M54 to M6 Link Road TR010054

8.8 LIU(K) Draft Statement of Common Ground with Nurton Developments (Hilton) Limited

January 2021

**8.8 LIU(K) Draft Statement of Common Ground with
Nurton Developments (Hilton) Limited**

DESIGN SPEED N/A  
(WORK No. 28)  
ACCOMMODATION OVERBRIDGE  
LONGITUDINAL SECTION CH. 0m - CH. 510m  
SCALE @ A1 - HORIZ 1:1250 VERT 1:250

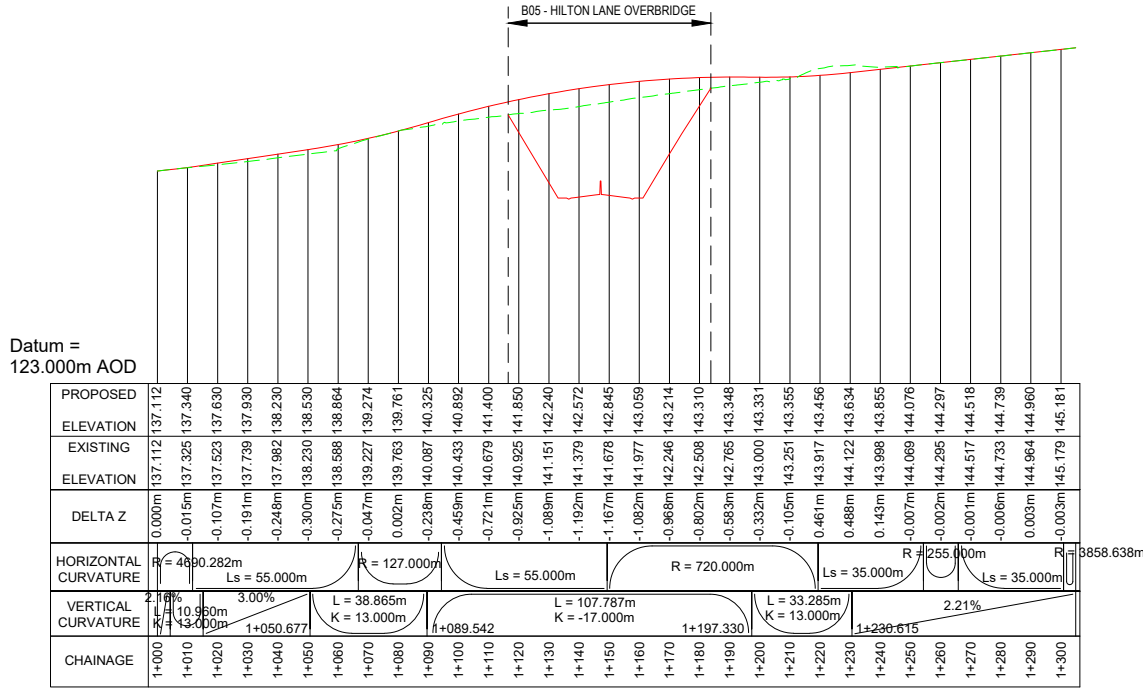
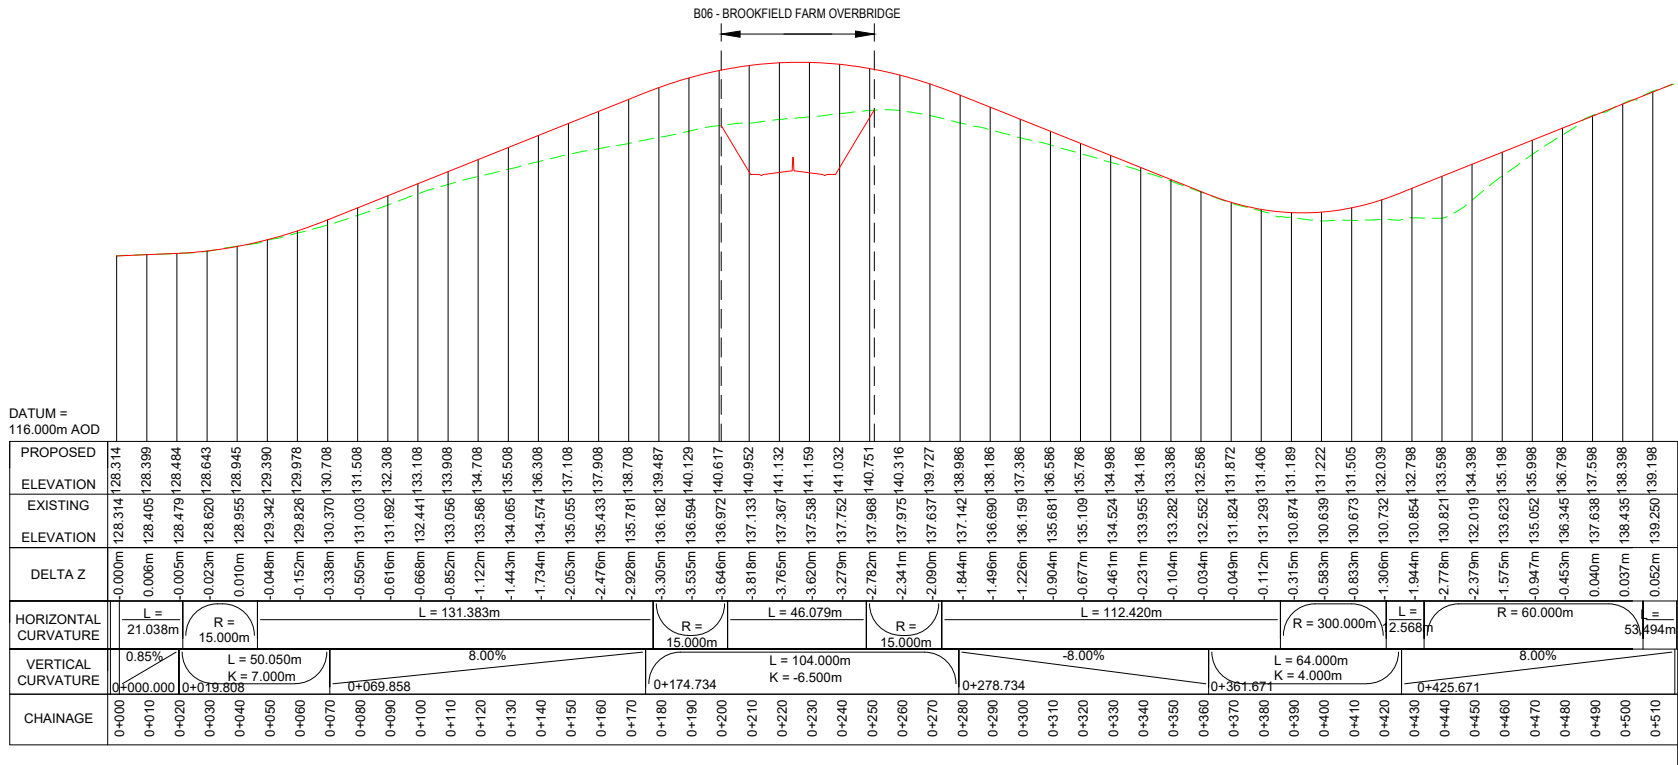
Relevant Rep. 038	(b) Bridge design and location at Hilton Land	Nurton has requested information from HE on the alternative solutions considered on the bridge design.	The bridges in question are the proposed bridge to be installed to enable Hilton Lane to cross the mainline and the accommodation bridge further north at Brookfield Farm to	Under discussion	Low

Document	Subject	Nurton Developments Limited Comment	Highways England Response	Status	Agreement likely ¹
	and Brookfield Farm		<p>access their land on the other side of the new link road for existing purposes.</p> <p>The alternatives considered have been discussed with Nurton prior to the submission of the Application, with further correspondence prior to Nurton submitting its Relevant Representation. This includes discussions at the meeting on 2 December 2019 (see Appendix C) and a letter from Highways England to Nurton on 20 February 2020 (see Appendix D). Several suggestions for the bridge have been put forward by Nurton, each of which are explored further below.</p> <p>1/ HE understands that Nurton would like the proposed accommodation bridge to be widened to accommodate traffic that may access employment development on adjacent land, should planning permission be granted for it in the future.</p> <p>A meeting was held between Highways England and Nurton on 2 December 2019 where this matter was discussed (please see minutes in Appendix C). At this meeting Nurton explained that to facilitate the development, the bridge should be 11.3 m wide (7.3 m road, 3 m footpath and 1 m verge) as opposed to the proposed 6 m wide</p>

Document	Subject	Nurton Developments Limited Comment	Highways England Response	Status	Agreement likely ¹
			<p>bridge (4.5 m road and 0.75 m verge on either side).</p> <p>As HE explained at the meeting on 2 December, the proposed increase in bridge width would increase costs and environmental impacts and therefore cannot be justified. The bridge design proposed to be constructed is typical of accommodation bridges to enable farm machinery to access adjacent plots of land. Following discussion with the landowners, Nigel and Paul Simkin, it was confirmed that the largest road legal combine harvester requires access across this structure (4m width). Therefore, the paved width across the bridge was increased from 4m to 4.5m.</p> <p>2/ HE has also considered Nurton's request to combine the bridge at Hilton Lane and the accommodation bridge, relocating it to a location between the two. Moving the bridge further from Hilton Lane would require construction of additional carriageway from Hilton Lane to the new bridge, resulting in significant additional costs and environmental impacts. It would require the acquisition of additional land that would not be justified in this instance. This was explained at the meeting on 2 December 2019 and in the</p>

Document	Subject	Nurton Developments Limited Comment	Highways England Response	Status	Agreement likely ¹
			<p>letter from HE to Nurton Developments on 20 February 2020.</p> <p>At the meeting on 2 December 2019, HE also explained that three alternatives had been considered for the location of the accommodation bridge:</p> <ul style="list-style-type: none"> (i) a main crossing over Hilton Lane; (ii) a crossing midway between Hilton Lane and proposed location; (iii) the proposed location. <p>It was considered that the proposed location was the best balance between the diversion length of the bridleway (already at 12% of its total length against a guideline maximum of 10%) and allowing an appropriate gradient (which will now be 8%) for the ramp up to the crossing.</p> <p>HE considers that sufficient information has been provided on the alternatives considered for this bridge and that reasonable alternatives have been considered.</p>
